PROJECT #: 21-2780.1-A (LOT 1)
LOT 1, WOODBRIDGE SOUTH
AUGUST 21, 2024
PAGE: 1 OF 1
RE: STUDS AT REAR DOOR

The Apex
 Garage Left

S-2.1.1

S-2.1.1

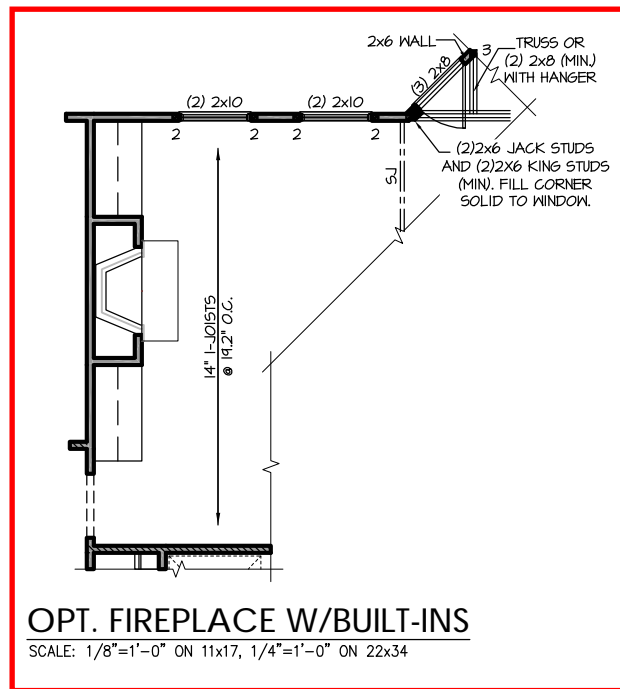
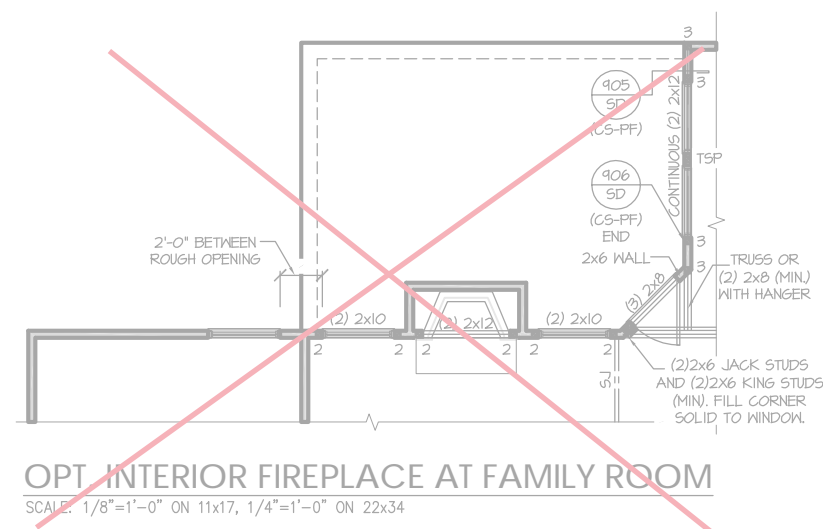
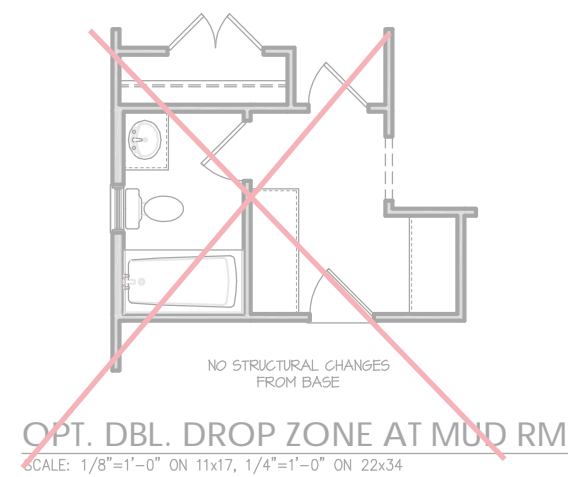
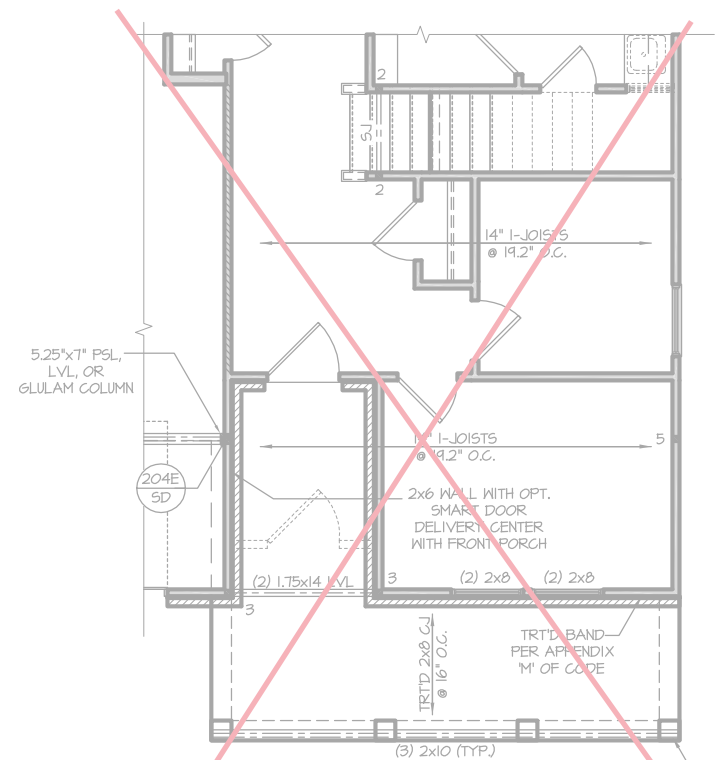
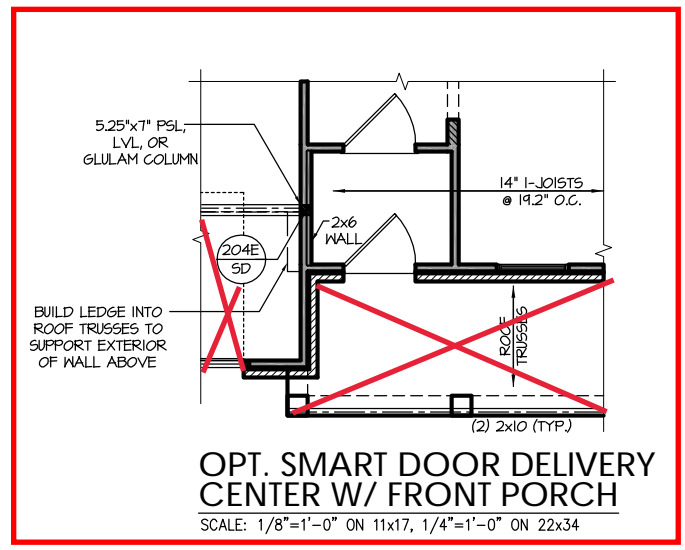
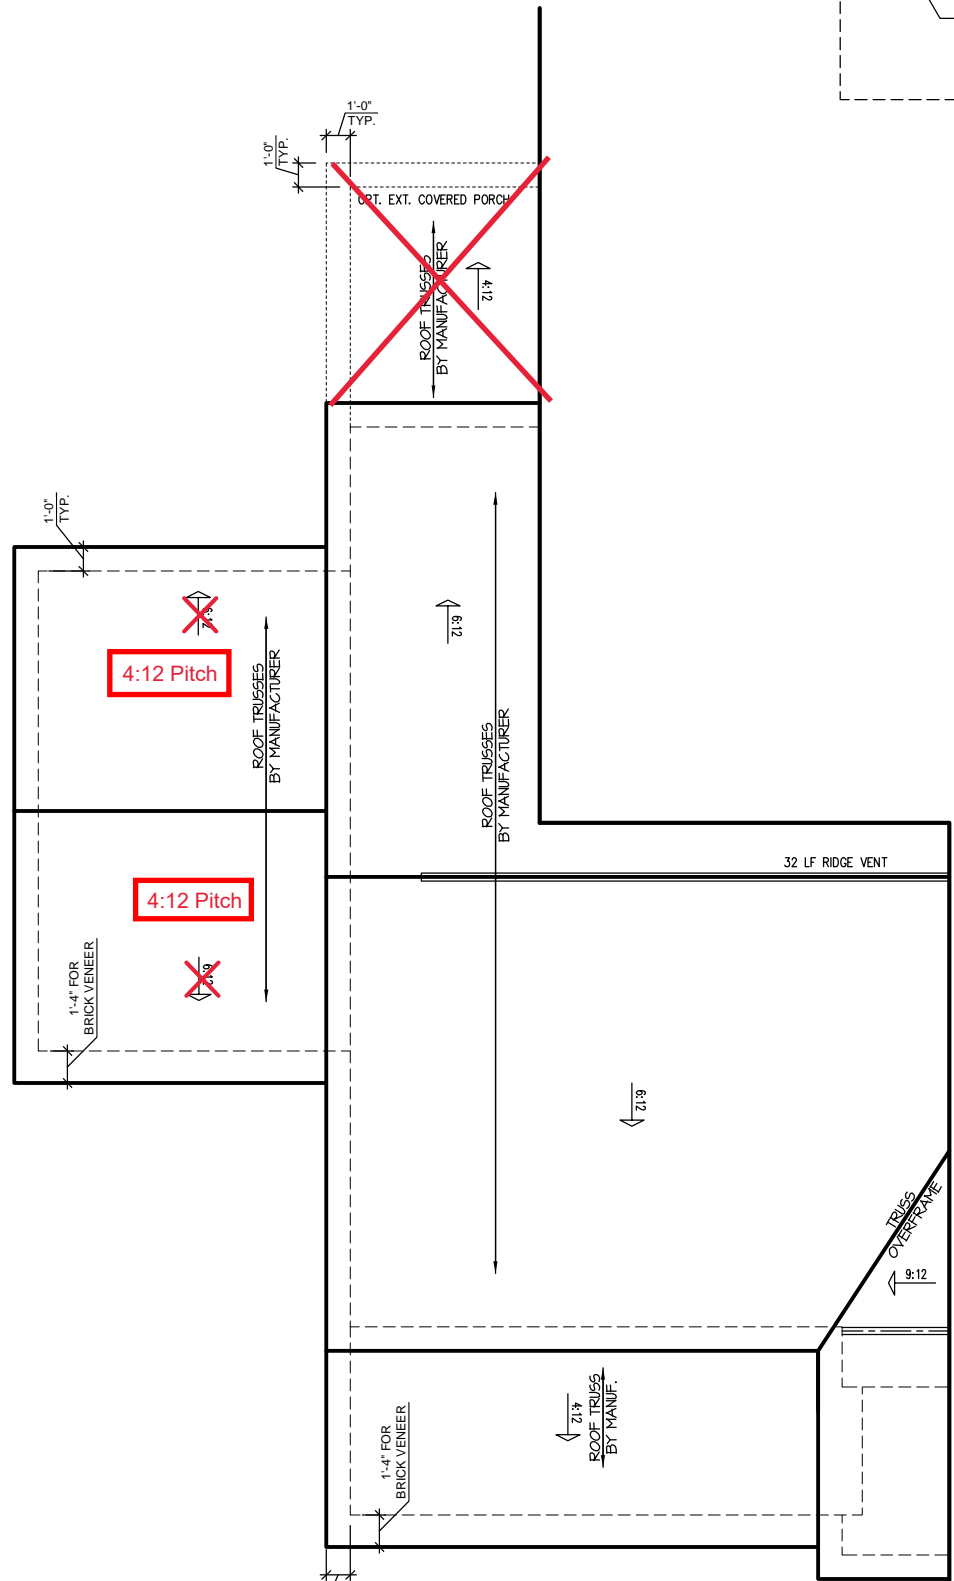
TOTAL STUD COLUMN IS SINGLE JACK STUD, (2) KING STUDS, AND (3) 2X4 STUDS ON LEFT SIDE OF CORNER. W-10X26 EXTENDS 5-1/2" PAST CORNER.
